22 October 2010

Sydney
WATER

Re: MP10_0060 - Environmental Assessment for the proposed redevelopment of Sydney Fish Markets

CONCEPT DESIGN - EXTENT OF WORKS AND LEASE BOUNDARIES FOR WATERFRONT WORKS

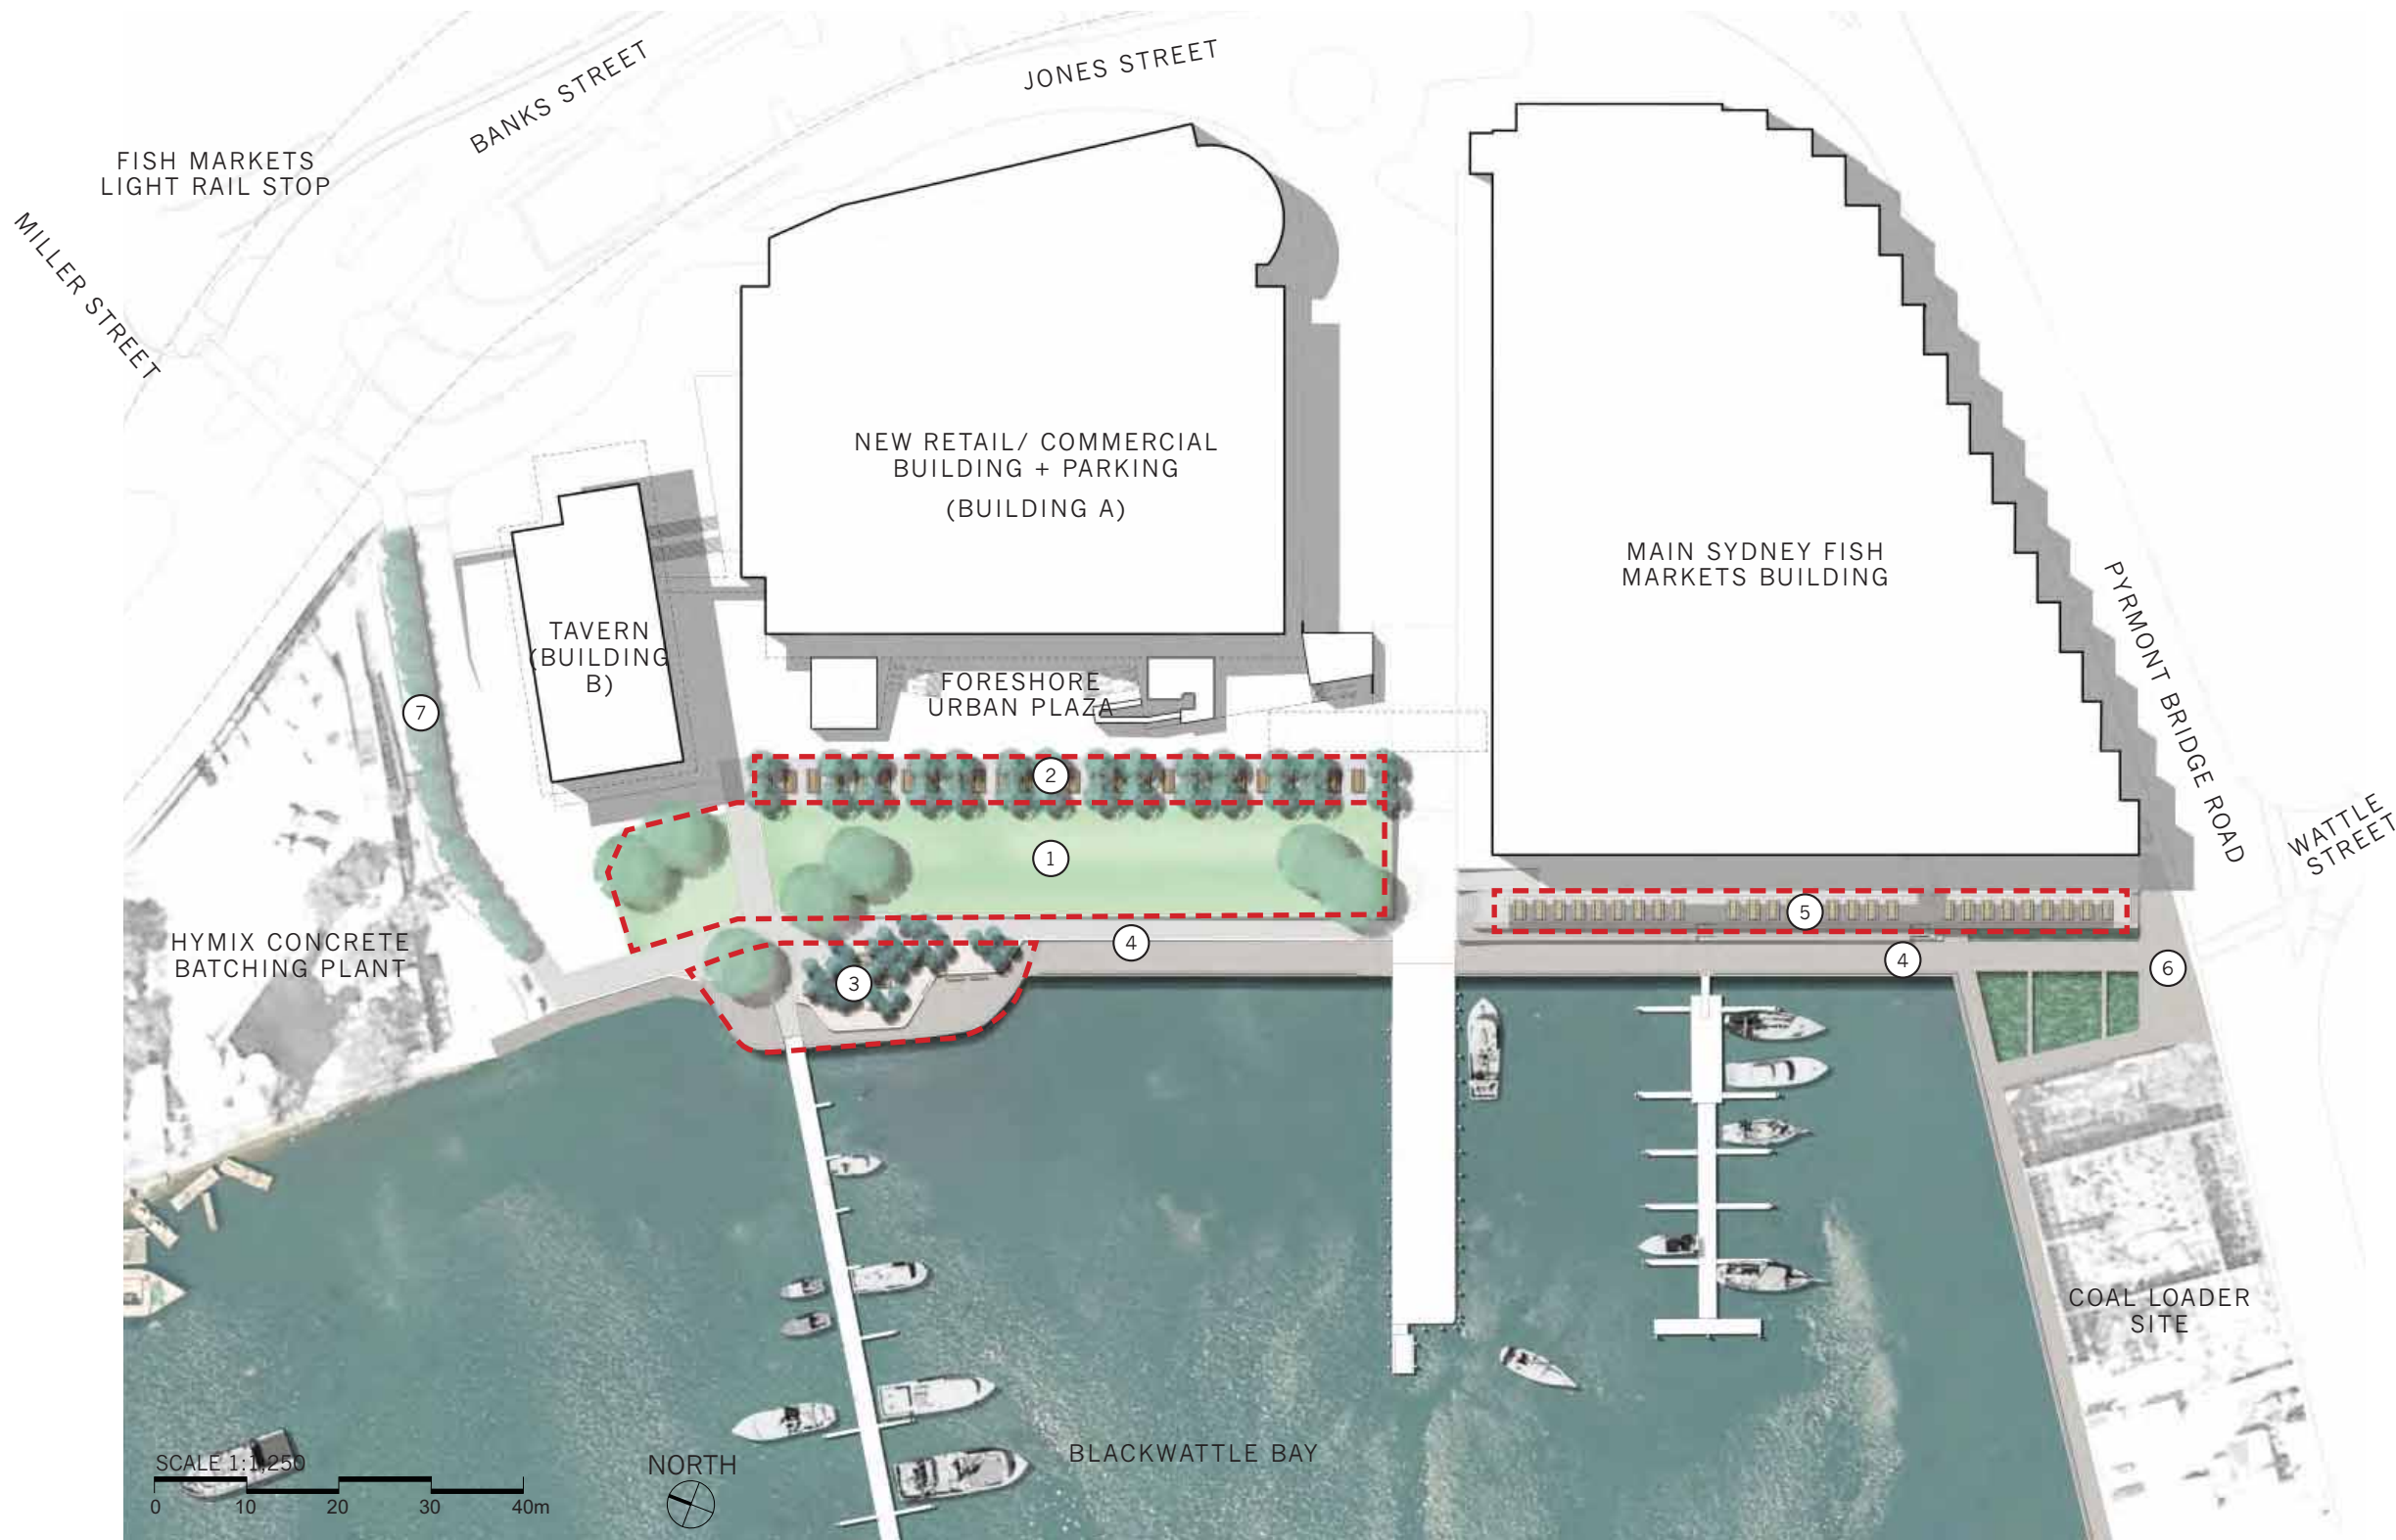
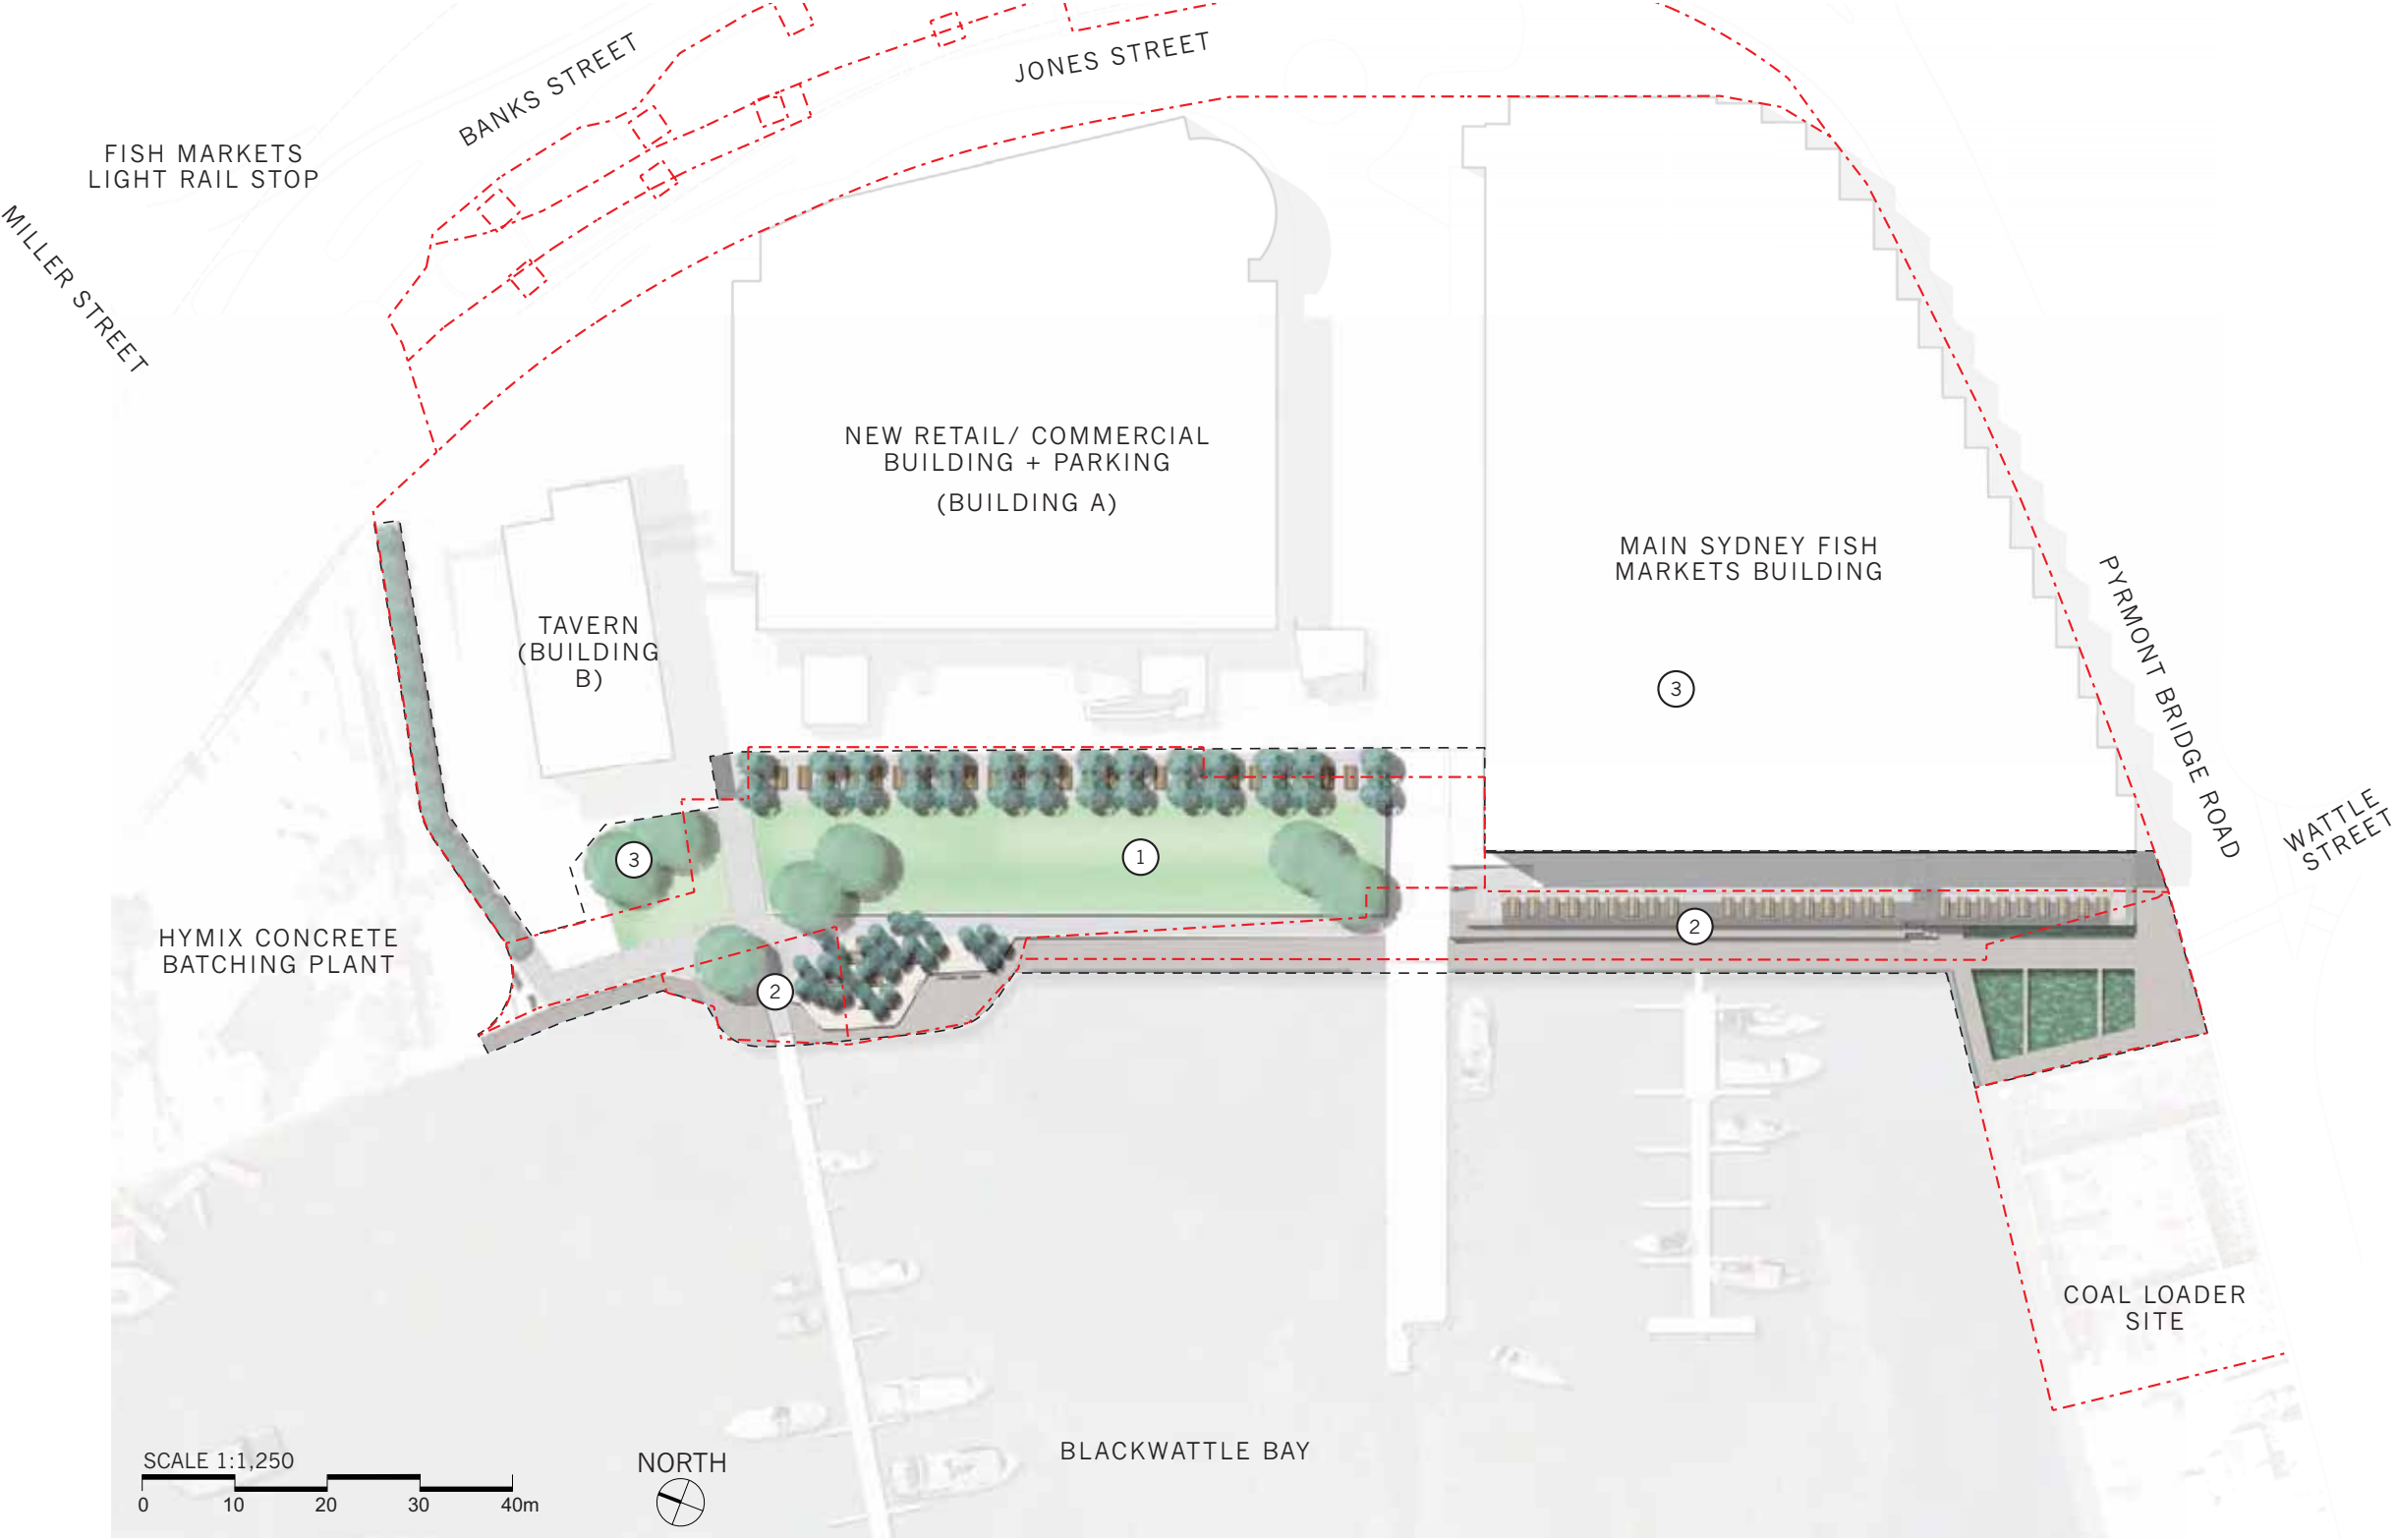
As extensive redevelopment of the waterfront area is proposed, Sydney Water requests further detailed information that describes the integration of the proposed main wharf, ramp and promenade with the existing stormwater outlet. In this regard, Sydney Water requires the outlet to be easily accessible and maintainable at all times.
